**Consultation Response from KC,  
Trees**

**2024/92236 Wood Street Mills, Wakefield Road, Scissett, Huddersfield, HD8 9JS**

**Demolition of existing industrial building and erection of storage and distribution building with car park and associated engineering works**

**Date Responded: 12/09/2024**

Title:  
Proposed Site Plan (Floor Plan)

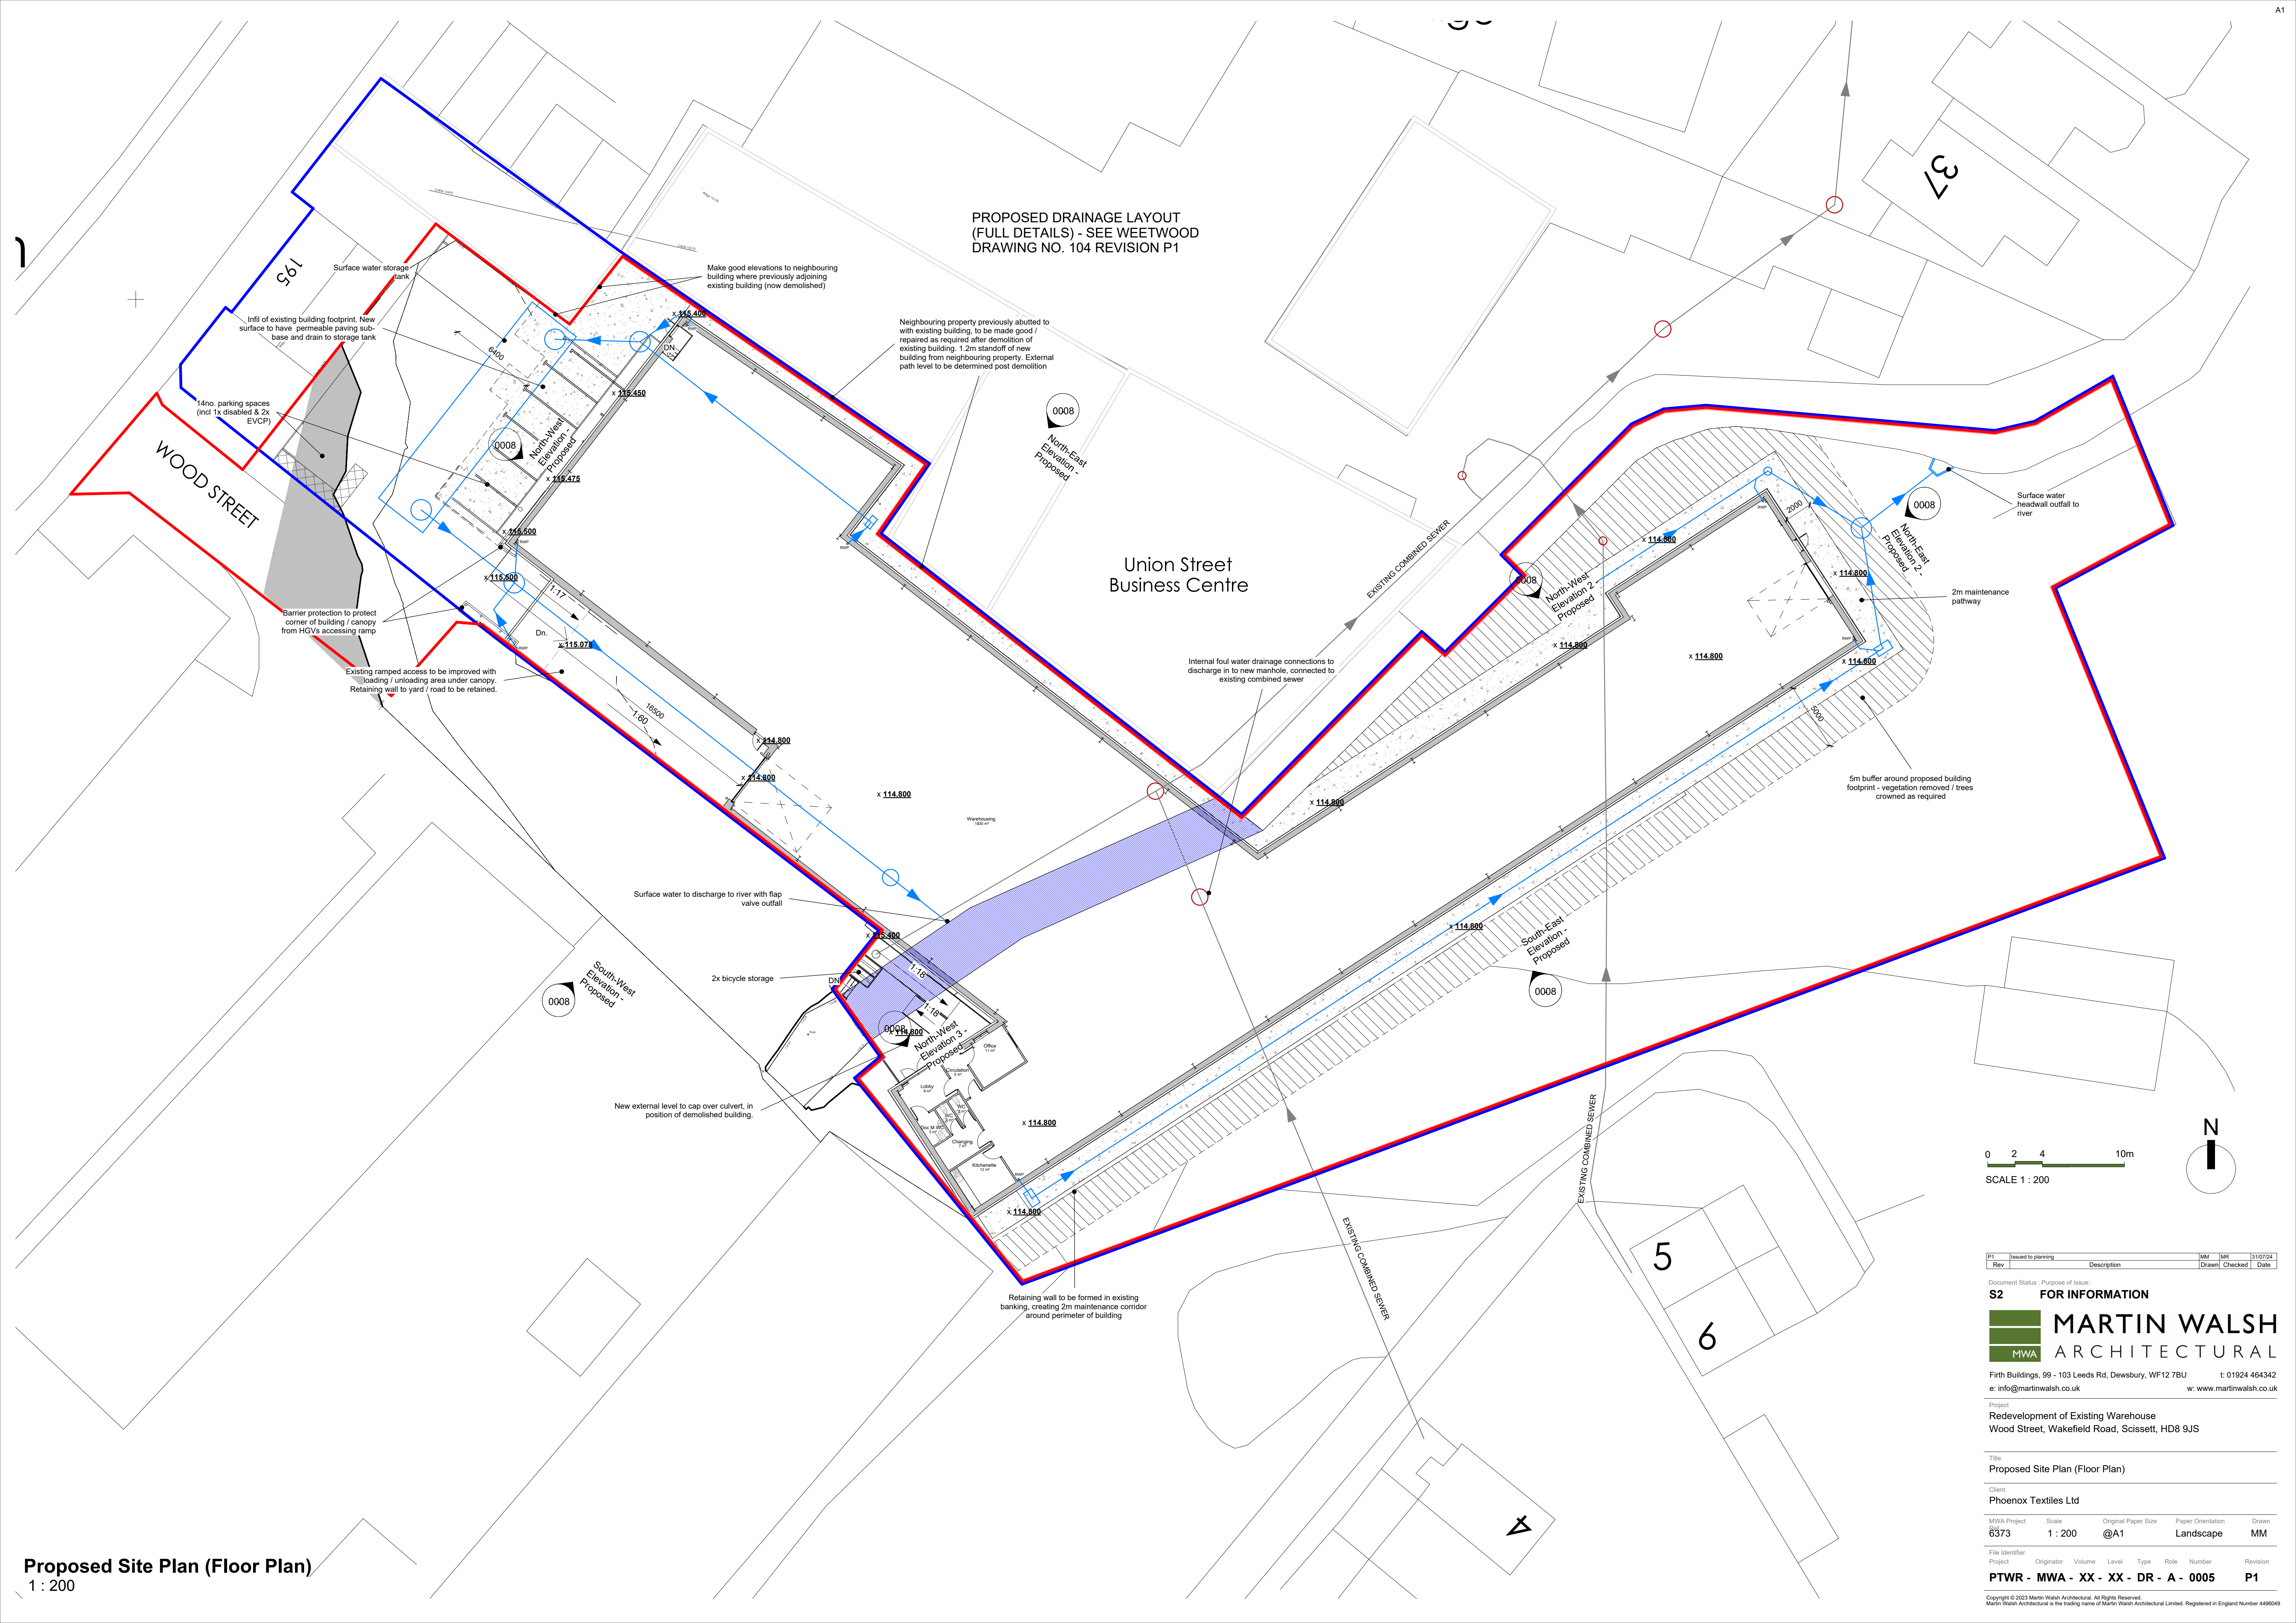
There largely seems to be no impact on any trees to the north section of the site, however the demolition and re-building of the southern section appears to have a large impact on the surrounding trees.

An Arboricultural Impact Assessment (AIA) would be required to judge the level of tree work required to facilitate the proposals and Arboricultural Method Statement (AMS) would be required to detail the methods and steps taken during construction to protect the surrounding trees.

There is a **holding** objection from a trees perspective until the suggested tree information is submitted.
